**Planning Department  
Transportation Development Services**

December 22, 2014

**Re: A-Class Storage on 2<sup>nd</sup> Street, 5124 Second Street  
Traffic Circulation Layout**  
Engineer's Stamp dated 12-01-14 (F15-D052B)

TRAFFIC CIRCULATION LAYOUT APPROVED

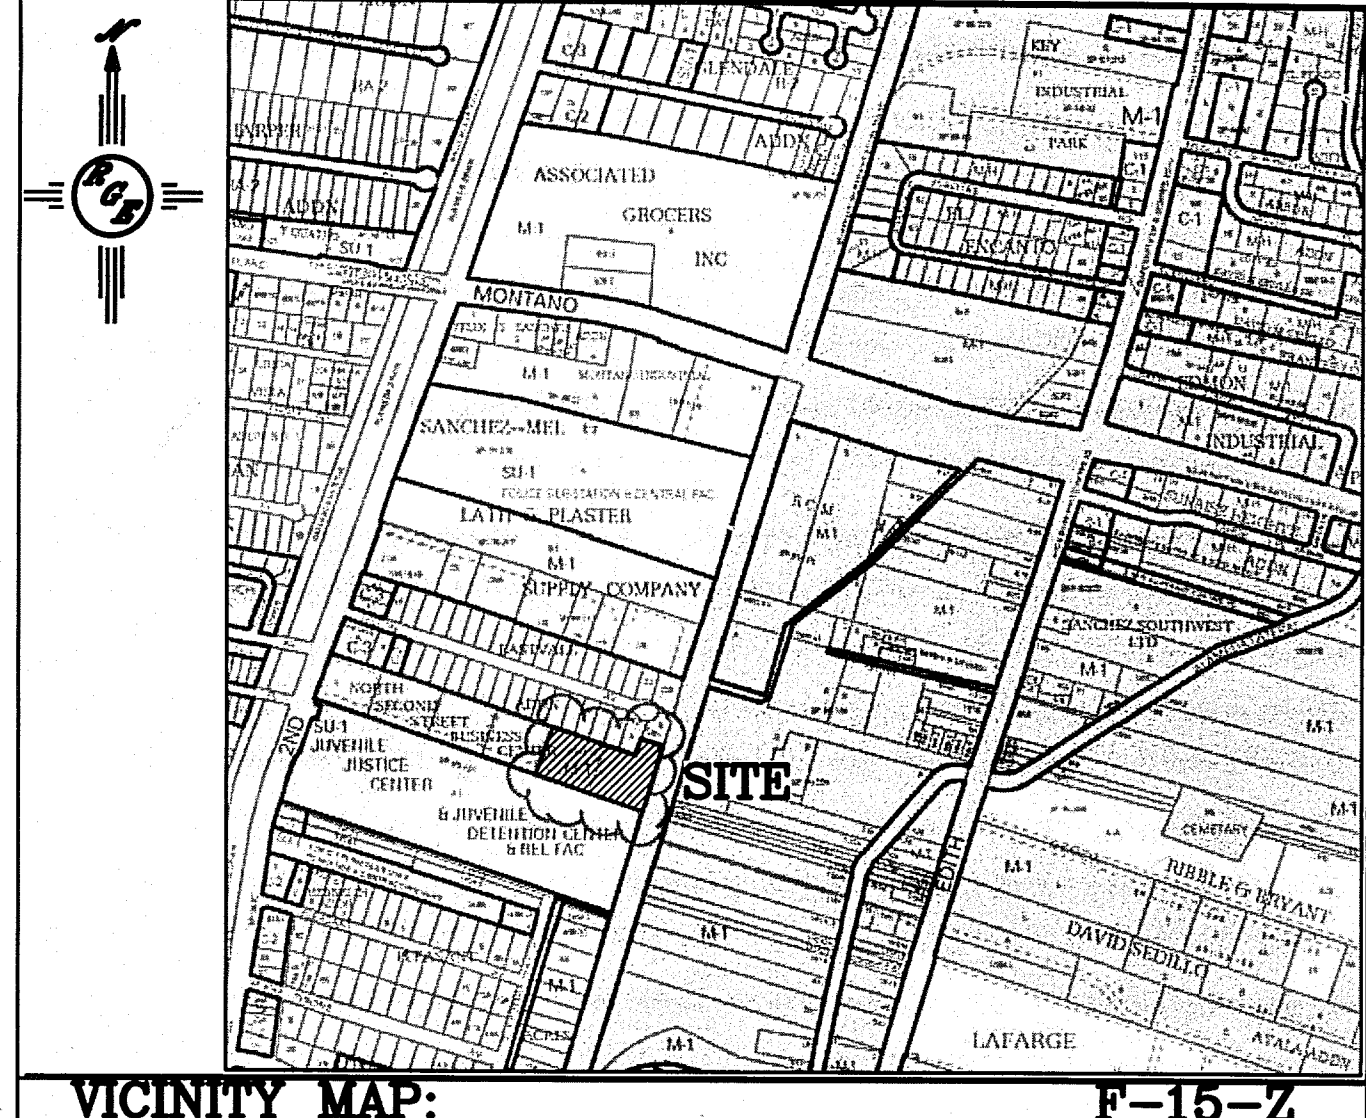
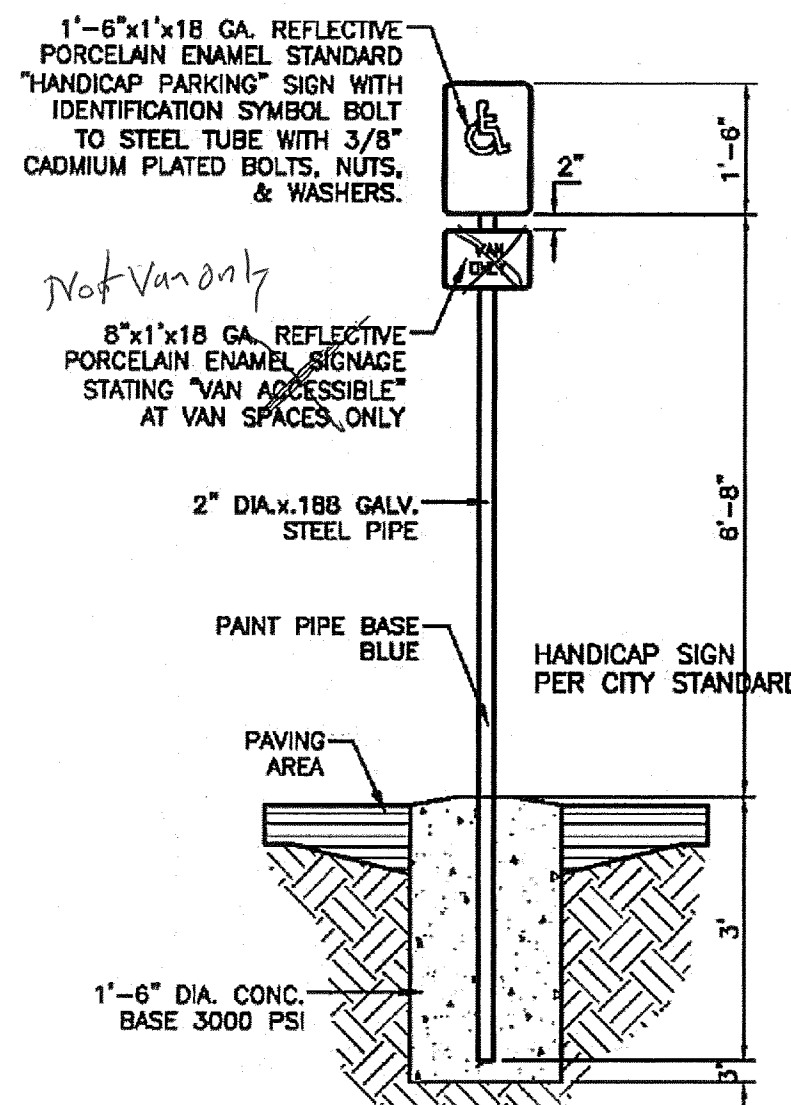
1. On the vicinity map, legibly call out the site location. Also, provide the site address on the plan.
2. Identify the access road easement width for the access road south of the site.

3. The dimensioning for the asphalt access through the site needs to be shown correctly for "54' " and "48' " dimensions. Call out edge of new asphalt, and provide pavement section for the asphalt drive.

4. Show both the north and south limit of the 34-foot motorized gate at the site entrance.
5. The ADA van accessible sign must have the required language per 66-7-352.4C NMSA 1978 **"Violators Are Subject to a Fine and/or Towing."** Call out the handicapped signage at the location of the handicapped space within the detail.

6. The ADA access aisle shall have the words **"NO PARKING"** in capital letters, each of which shall be at least one foot high and at least two inches wide, placed at the rear of the parking space so as to be close to where an adjacent vehicle's rear tire would be placed. (66-1-4.1.B NMSA 1978)

7. Per the DPM, a 6 ft. wide ADA accessible pedestrian pathway is required from the public sidewalk and from the HC parking stall access aisle to the building entrances. Call out the width of the sidewalk adjacent to the building as a minimum of 6 feet, and tie this sidewalk to the existing sidewalk on the access

8. Call out curb height for the curb along the handicapped parking spaces.
9. At both the 24-foot common access easement and at the intersection of the common access easement with the access road, there might be a sight distance issue. Provide a mini-clear site triangle (per page 23-28 of the DPM) at both of these sight locations. What type of 6-foot high fence is being installed near the motorized gate, and will it interfere with sight distance? Add the following note to the clear sight triangles: "Landscaping and signage will not interfere with clear sight requirements. Therefore, signs, walls, trees, and shrubbery between 3 and 8 feet tall (as measured from the gutter pan) will not be acceptable in this area."
